**City of Portland, Maine - Building or Use Permit Application**  
 389 Congress Street, 04101 Tel: (207) 874-8703, Fax: (207) 874-8716

**PERMIT ISSUED**  
 Permit No: 02-0916 Issue Date: AUG 15 2002  
**CITY OF PORTLAND**

**Proposed Project Description:**  
Construct an 8' x 12' Wood Shed

SHEET OF SURVEY
43 HERSEY AVENUE
PORTLAND, ME

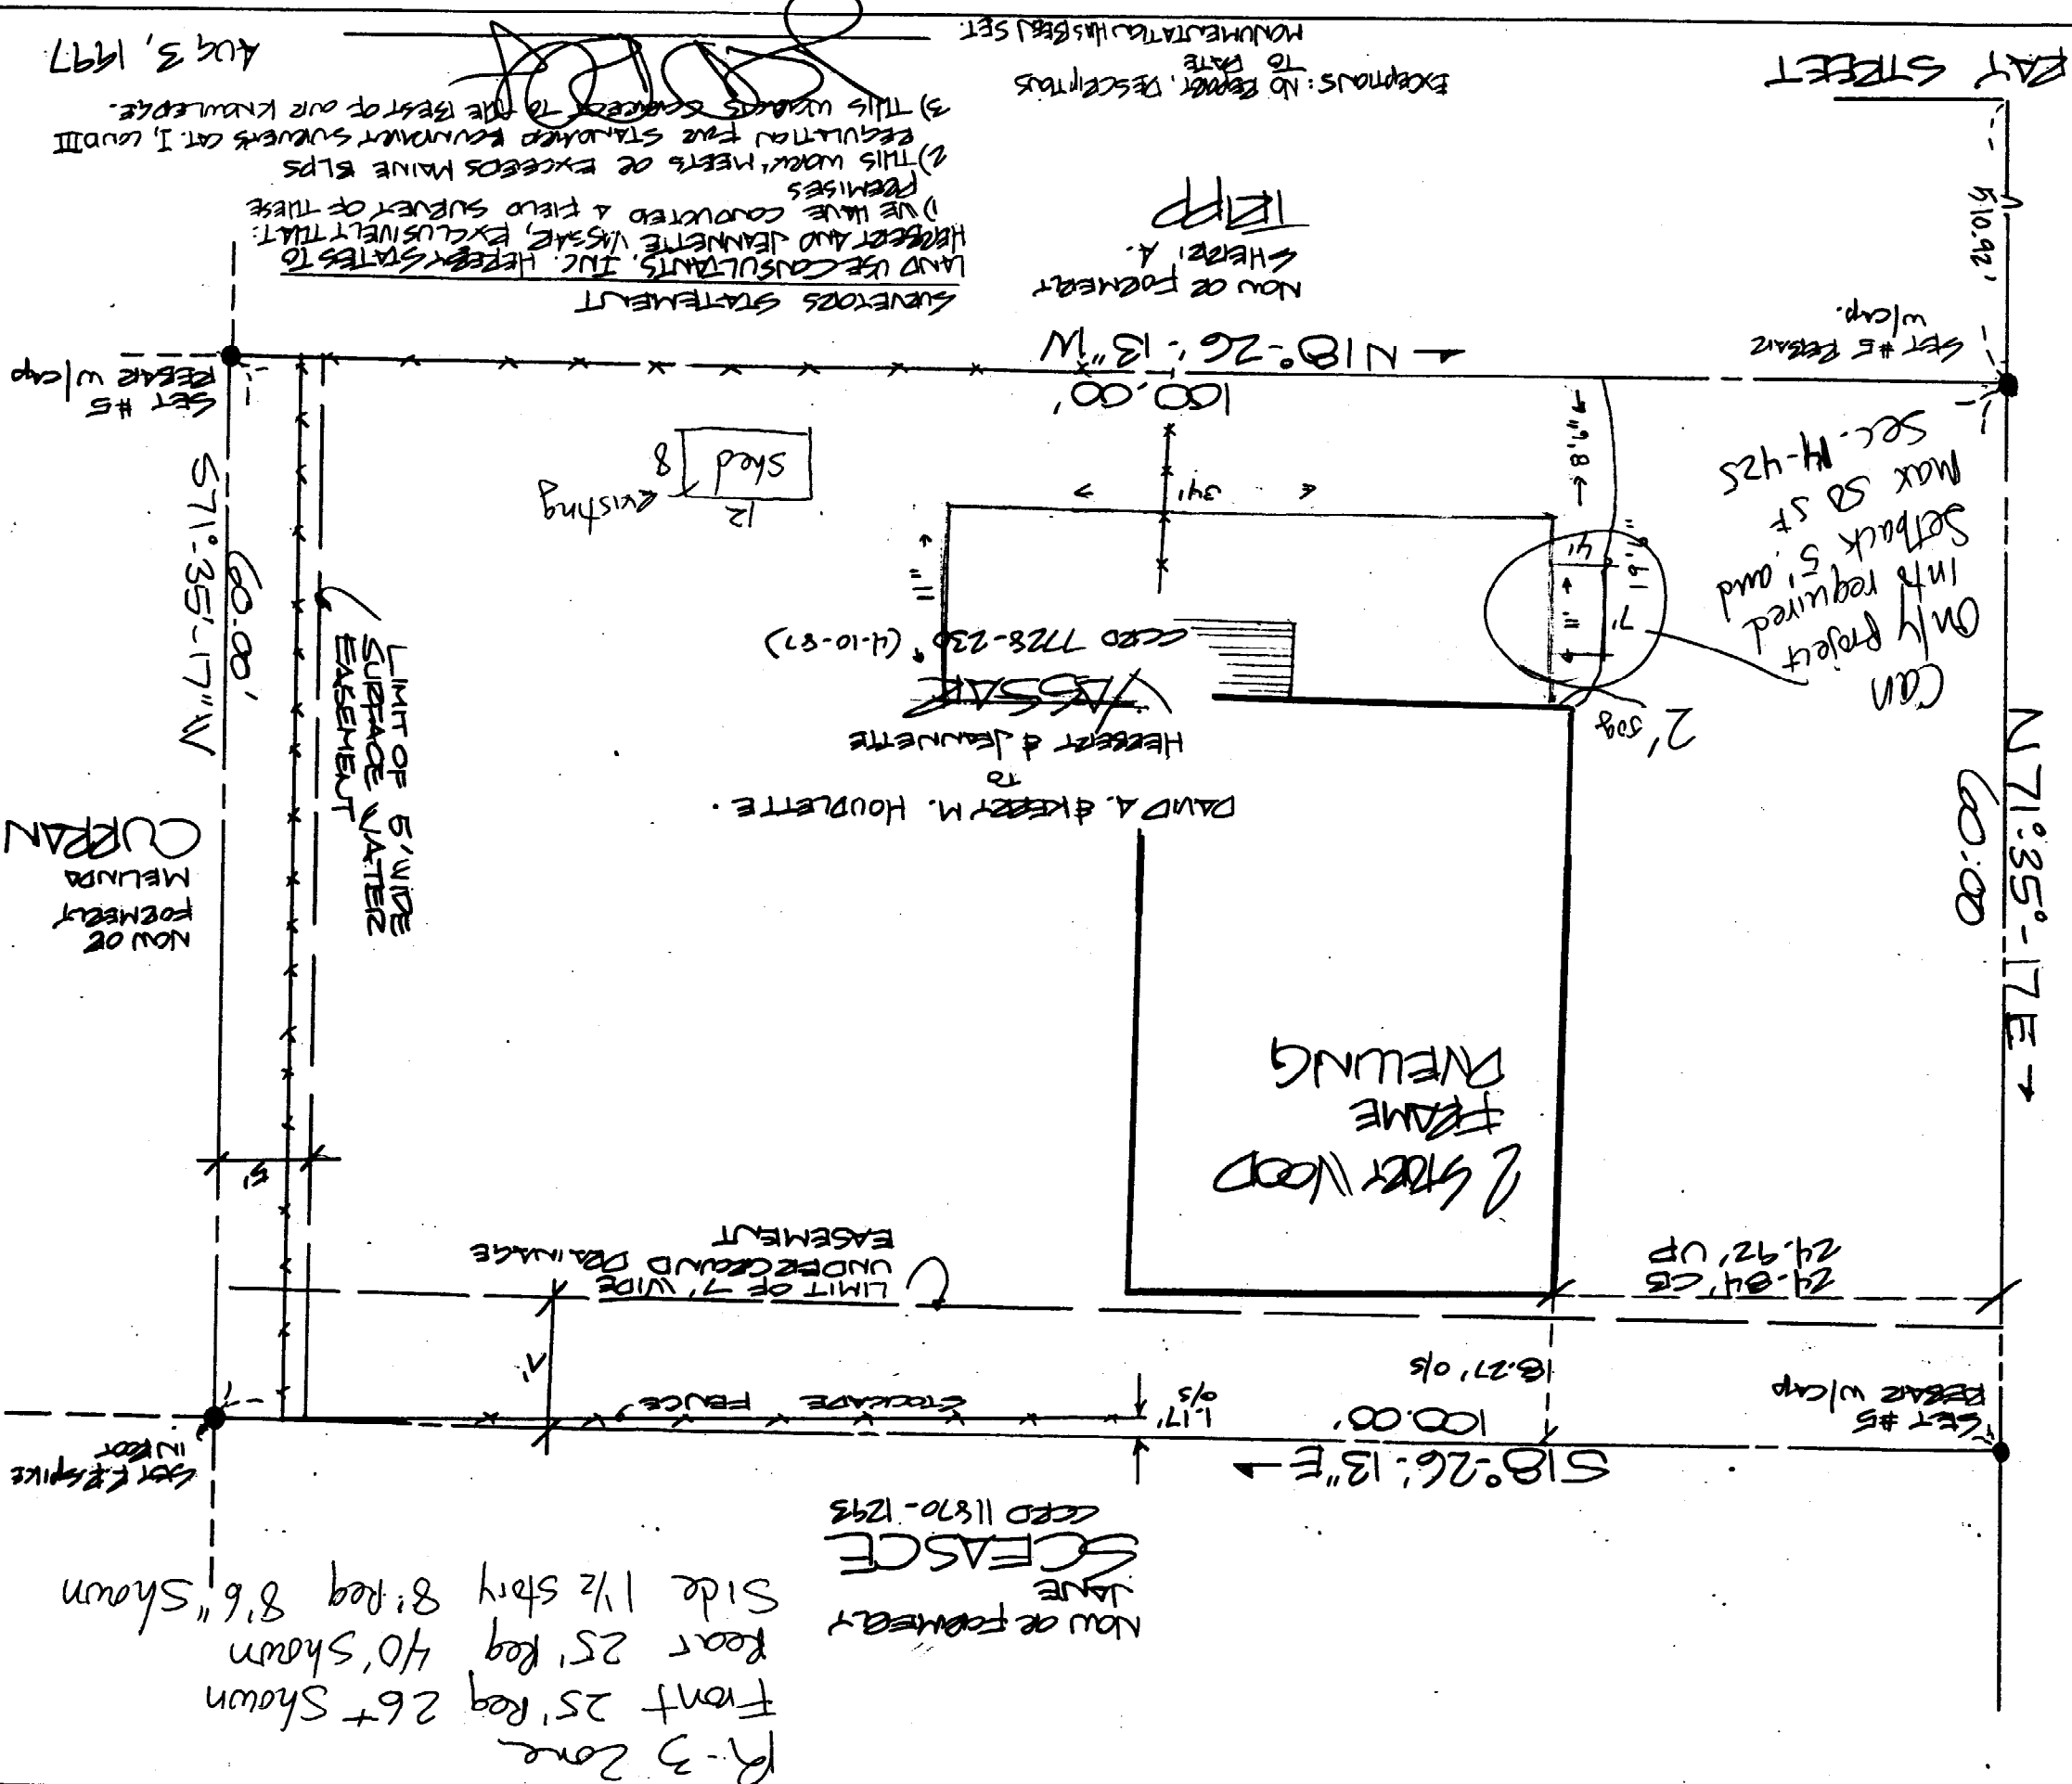
Comment Date	Comment	Name	Follow Up Date	Completed
08/14/2002	left message for owner - cited shown 3' from rear line - must be 9' - gave them file into data - asked them to call if they had questions.	imm		<input type="checkbox"/>

Must be  
5' from  
Lines.
